## Ann Machado - Mayfield Street & 14-403

**From:** Marge Schmuckal  
**To:** Ann Machado; Barbara Barhydt ; David Margolis-Pineo; Jennifer Thomps...  
**Date:** 5/20/2014 9:55 AM  
**Subject:** Mayfield Street & 14-403

I have reviewed 14-403 and used the information that I have gleaned about Mayfield Street.

BOUNDARY SURVEY
MAYFIELD STREET, PORTLAND ME.

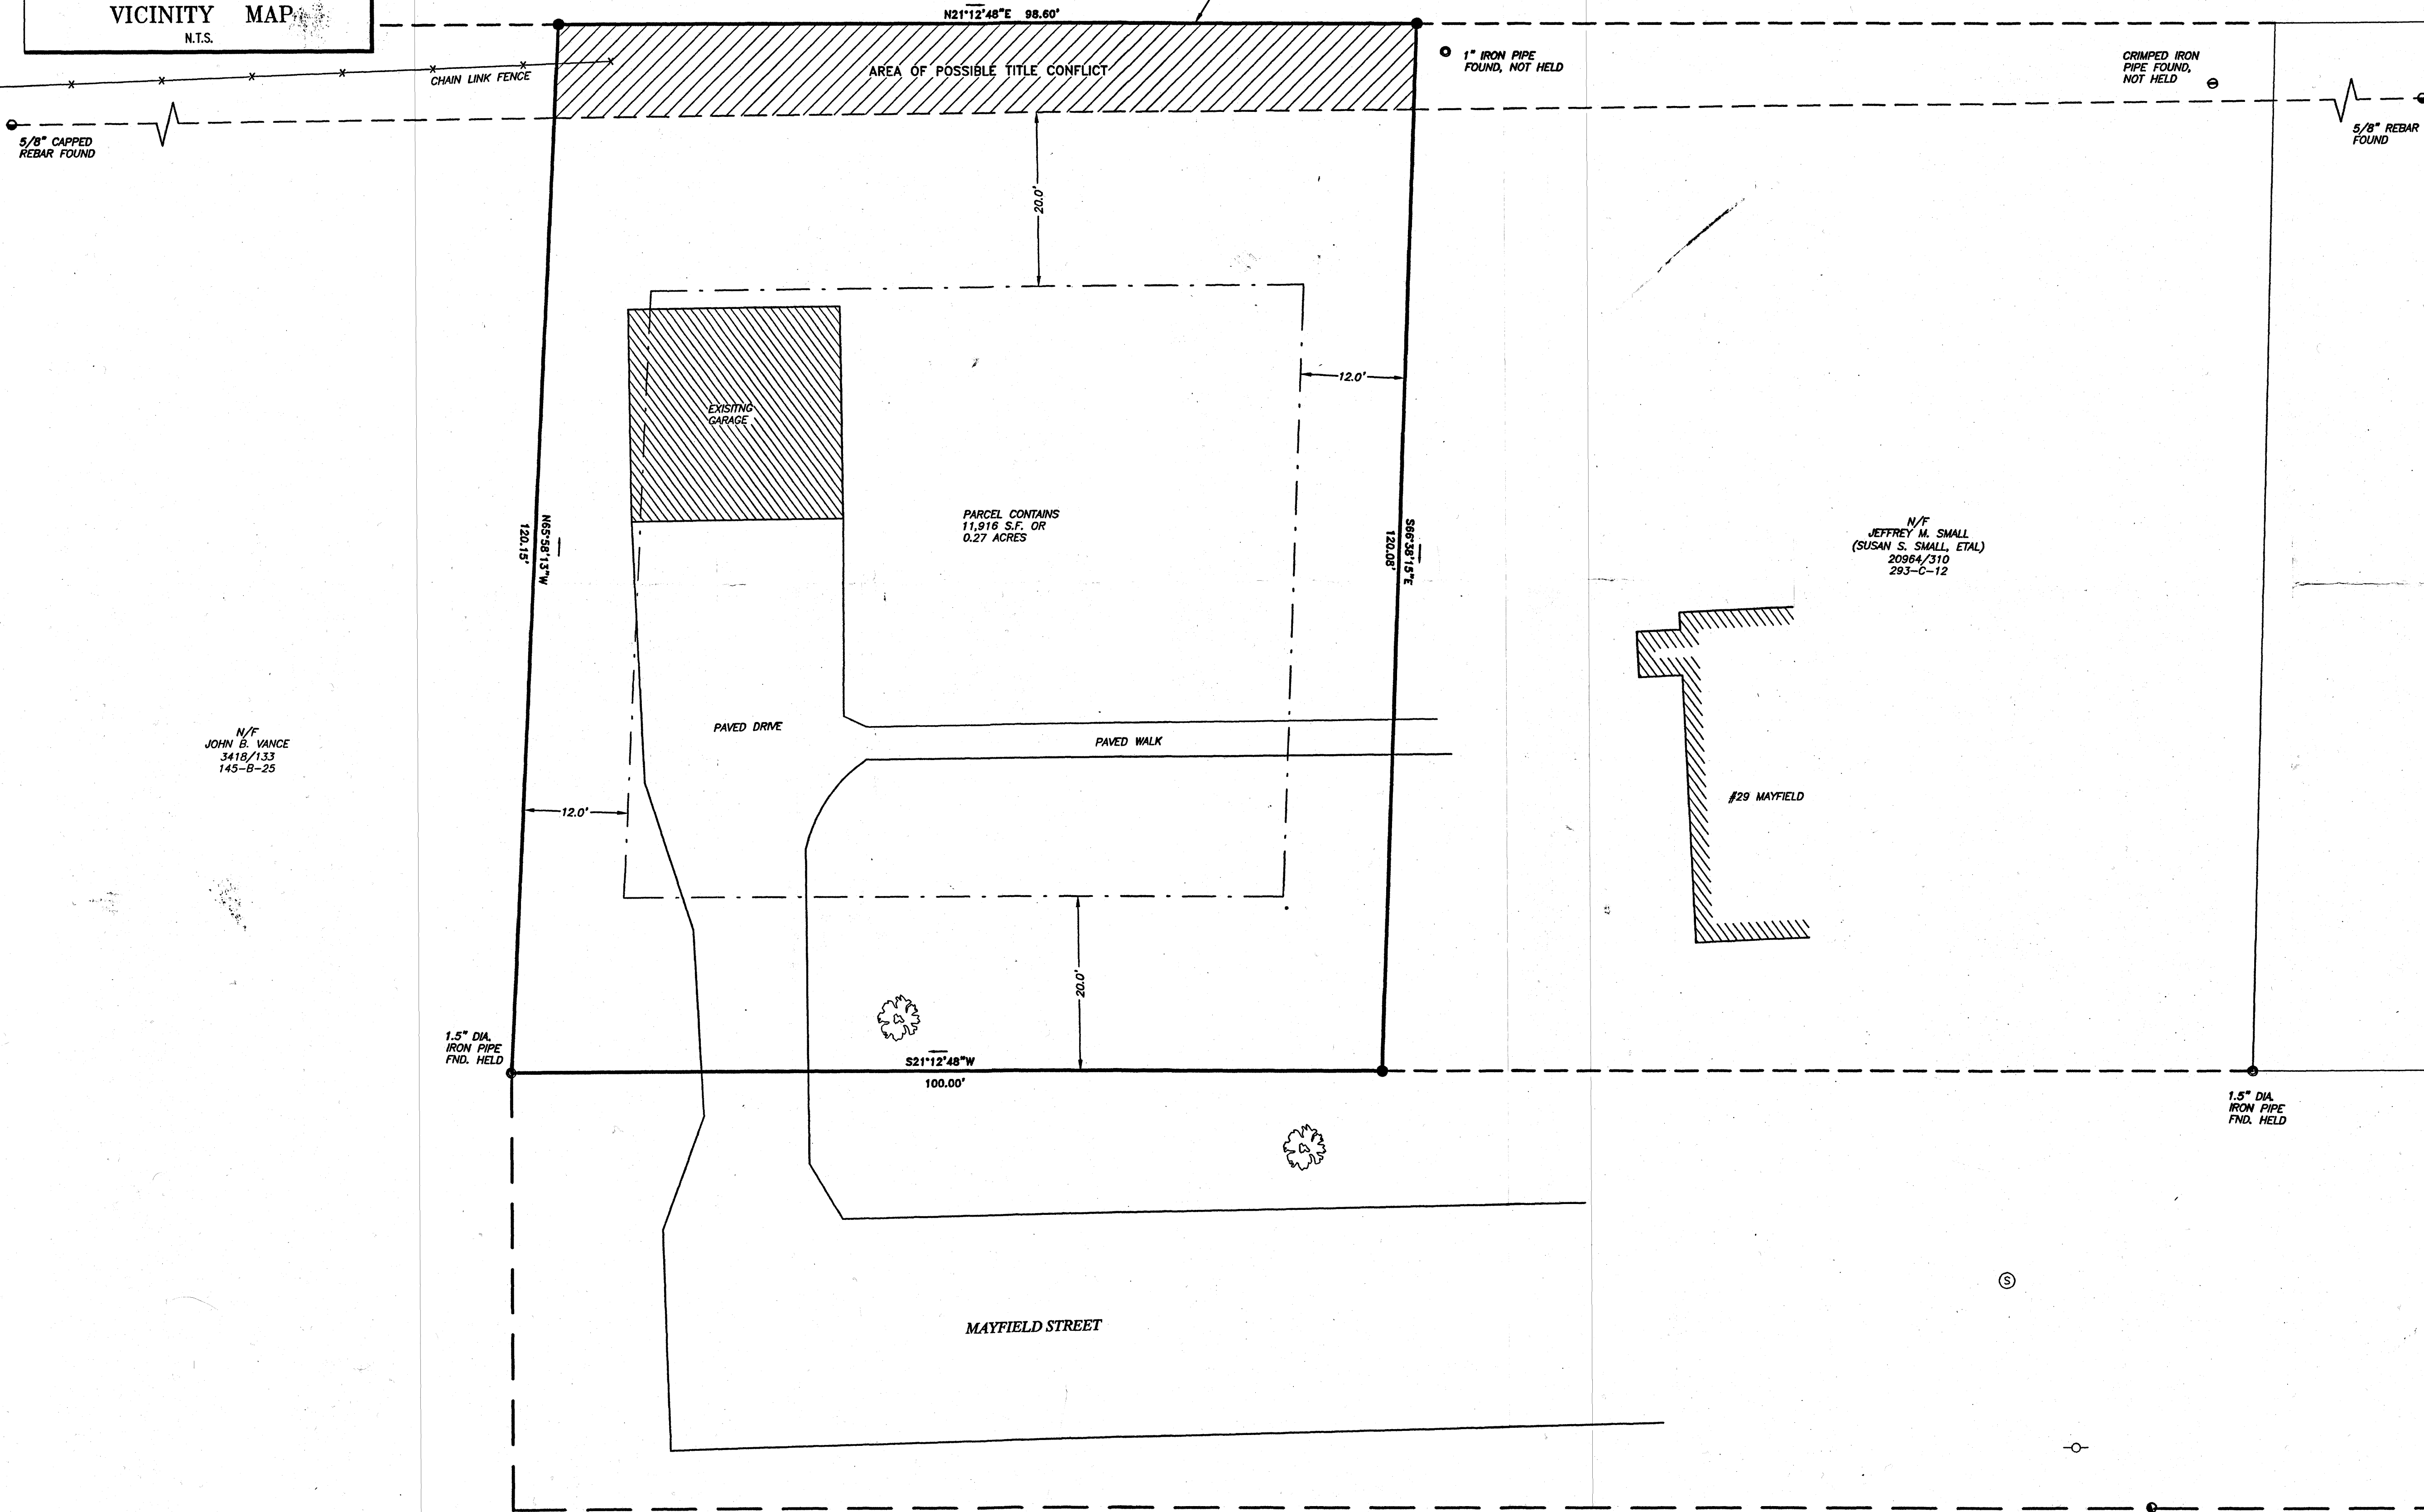
1.) The submitted survey shows the Mayfield right-of way to be 50' wide. This is based upon a survey "... for Fred E. Briggs, May 1013, by E.C. Jordan & Co., recorded at Cumberland County Registry of Deeds in Plan Book 12, Page 68." We will be requesting a copy of that survey for our files. The survey also shows the right-of-way continues to the end of the property of Susan Small. Therefore the first test of 14-403 has been met, which states that no building intended for habitation shall be erected on a lot which has its only street frontage on a street less than thirty-five (35) feet wide.
